Comments for Planning Application 19/05000/HYB

Application Number: 19/05000/HYB

Address: DSTL Fort Halstead Crow Drive Halstead Sevenoaks KENT TN14 7BU

Proposal: Hybrid application comprising, in outline: development of business space (use classes B1a/b/c) of up to 27,773 sqm GEA; works within the X enclave relating to energetic testing operations, including fencing, access, car parking; development of up to 635 residential dwellings; development of a mixed use village centre (use classes A1/A3/A4/A5/B1a/D1/D2); land safeguarded for a primary school; change of use of Fort Area and bunkers to Historic Interpretation Centre (use class D1) with workshop space and; associated landscaping, works and infrastructure. In detail: demolition of existing buildings; change of use and works including extension and associated alterations to buildings Q13 and Q14 including landscaping and public realm, and primary and secondary accesses to the site.

**Figure B1 Fort Halstead Development Vehicle Flows AM Peak (0800-0900)**  
 Note: Numbers in the red box represent the different feed points, as defined within the report

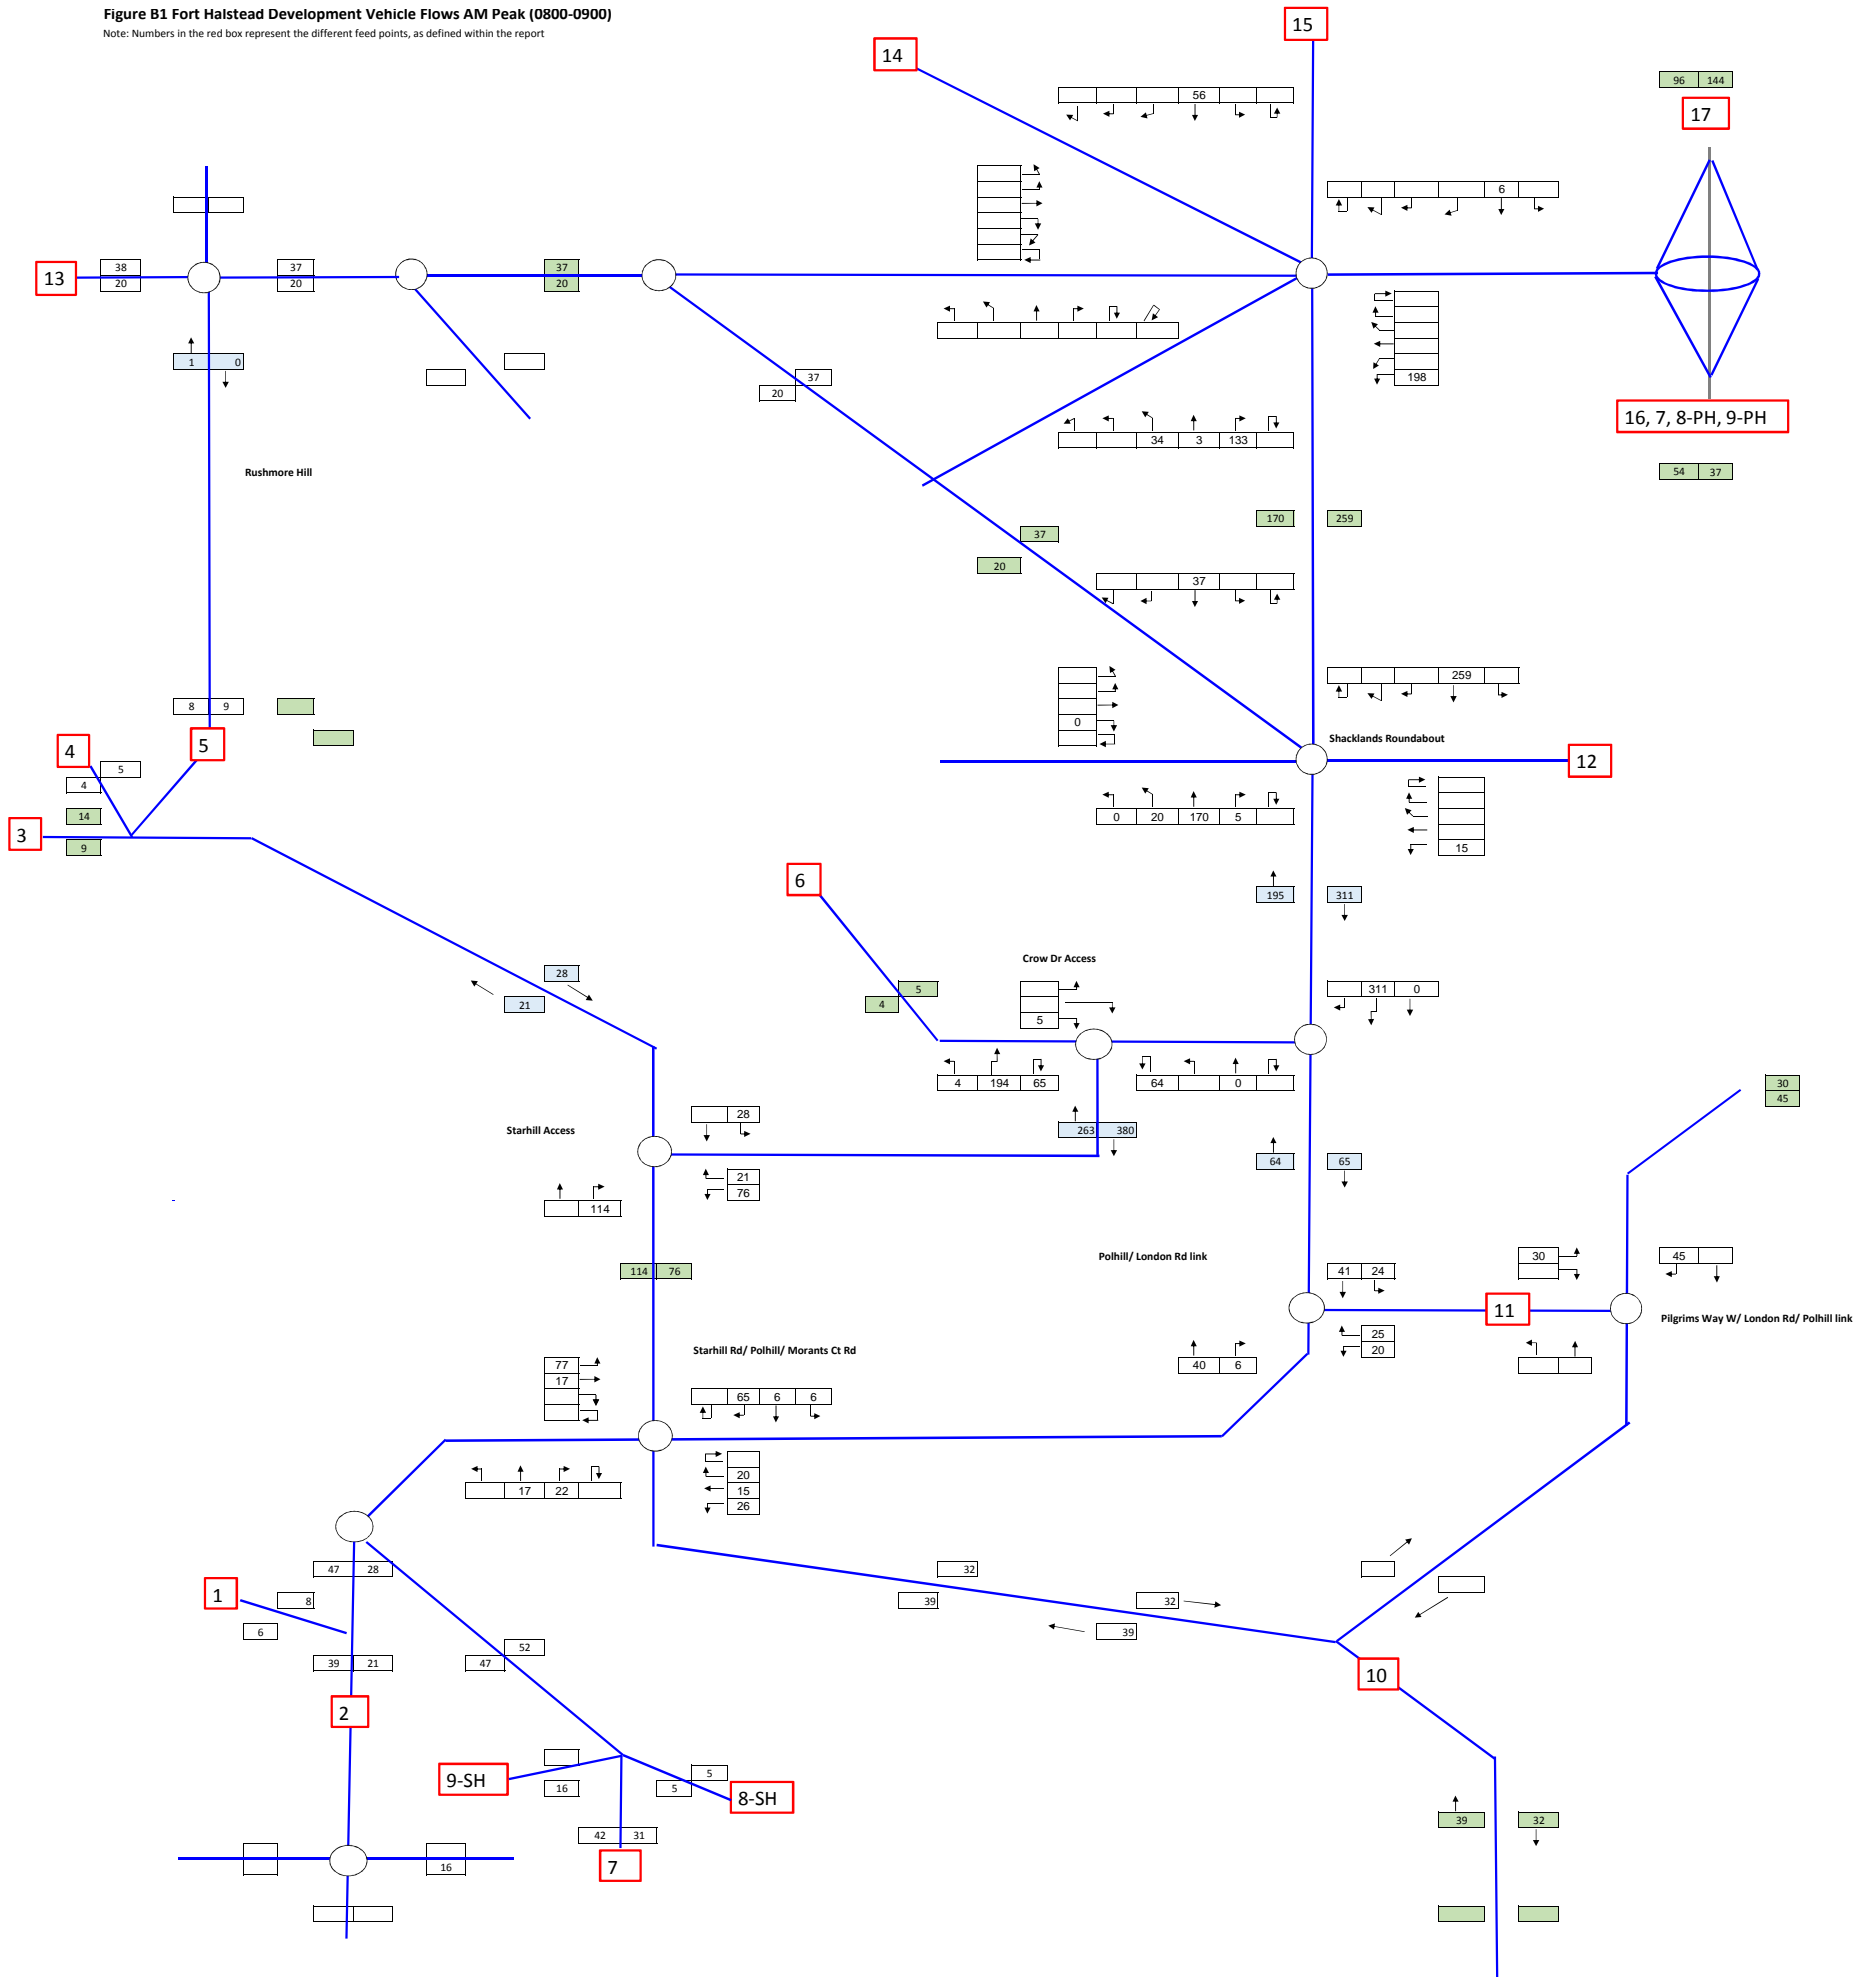
Figure B1 to record 0 & 1 Rushmore Hill, 9 on Main Road is ridiculous. The whole of Appendix B is inaccurate and provides misleading information. The developers were aware of this but still submitted false data.
